Subject: RE: FAO Zac Denton - Bilsham Croft, Bilsham Lane, Bilsham, West Sussex. BN18 0JX - PP-06970965 - Y/44/18/HH

Re - Bilsham Croft, Bilsham Lane, Bilsham, West Sussex. BN18 0JX - PP-06970965 - Y/44/18/HH

Location Plan at 1:1250 scale

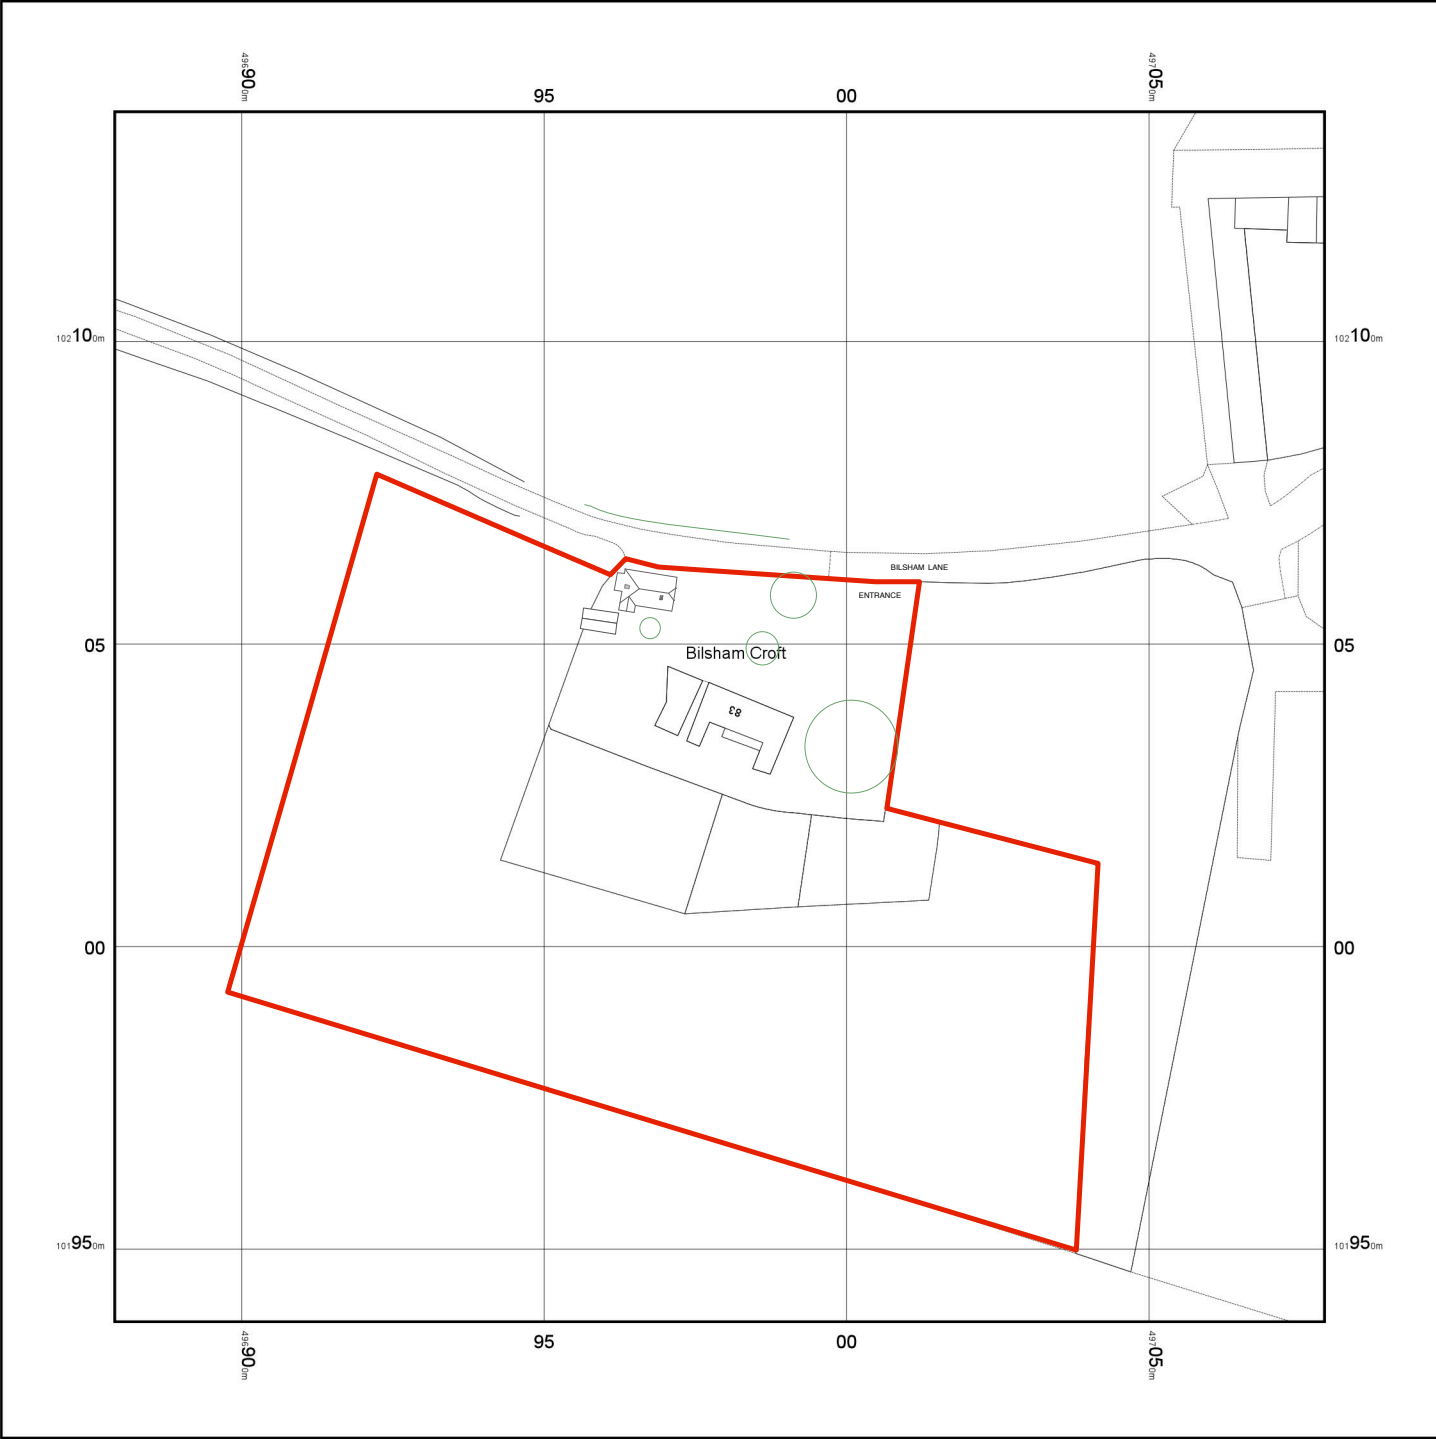
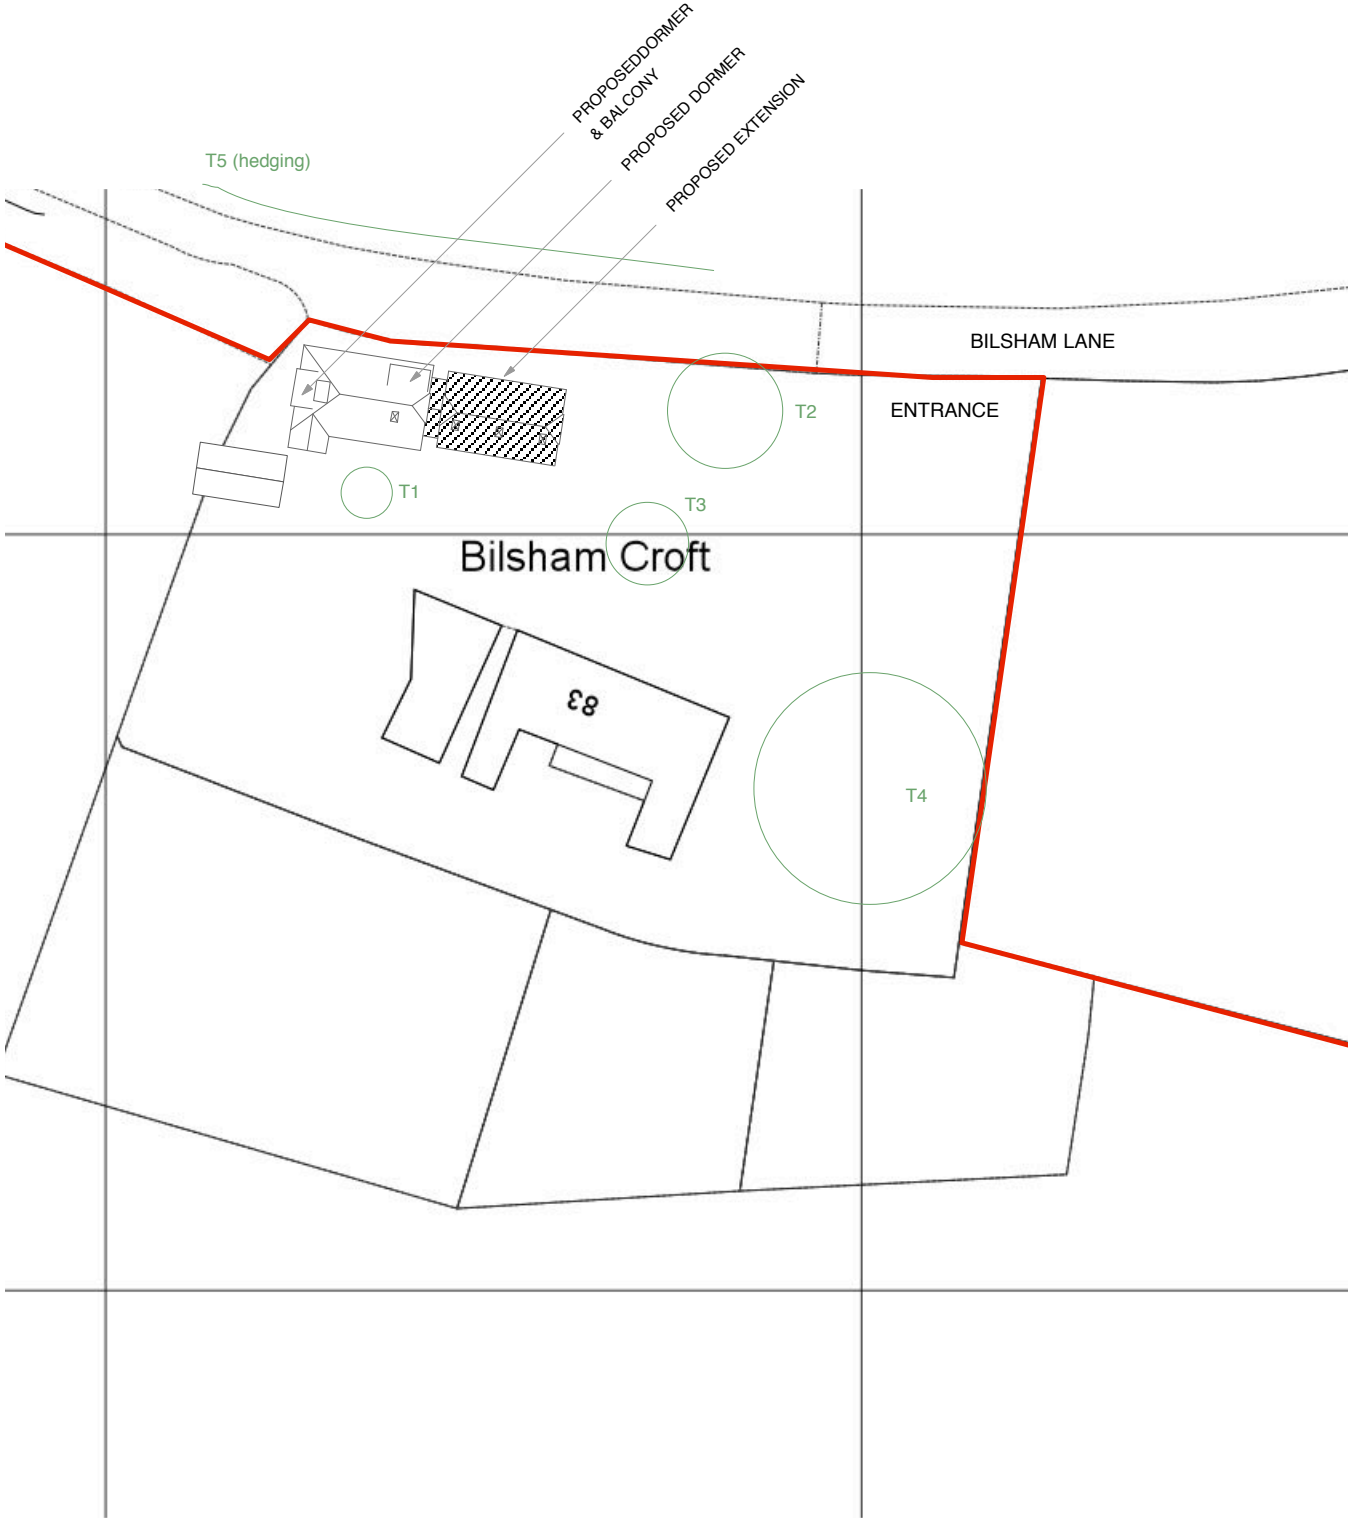
I do not believe that the current 'red edge' on your location plan is correct, I think that the red edge should be shown as on the attached plan (as the curtilage was in 2007), and the extra area should be contained within a 'blue edge'. The curtilage on the two applications should match.

Would you be able to submit an amended plan, showing this change?

Thank you for your email, please see attached updated 1:1250 / 500 plans showing site in red with applicant's remaining land-in-ownership in blue. Is this as you envisaged?
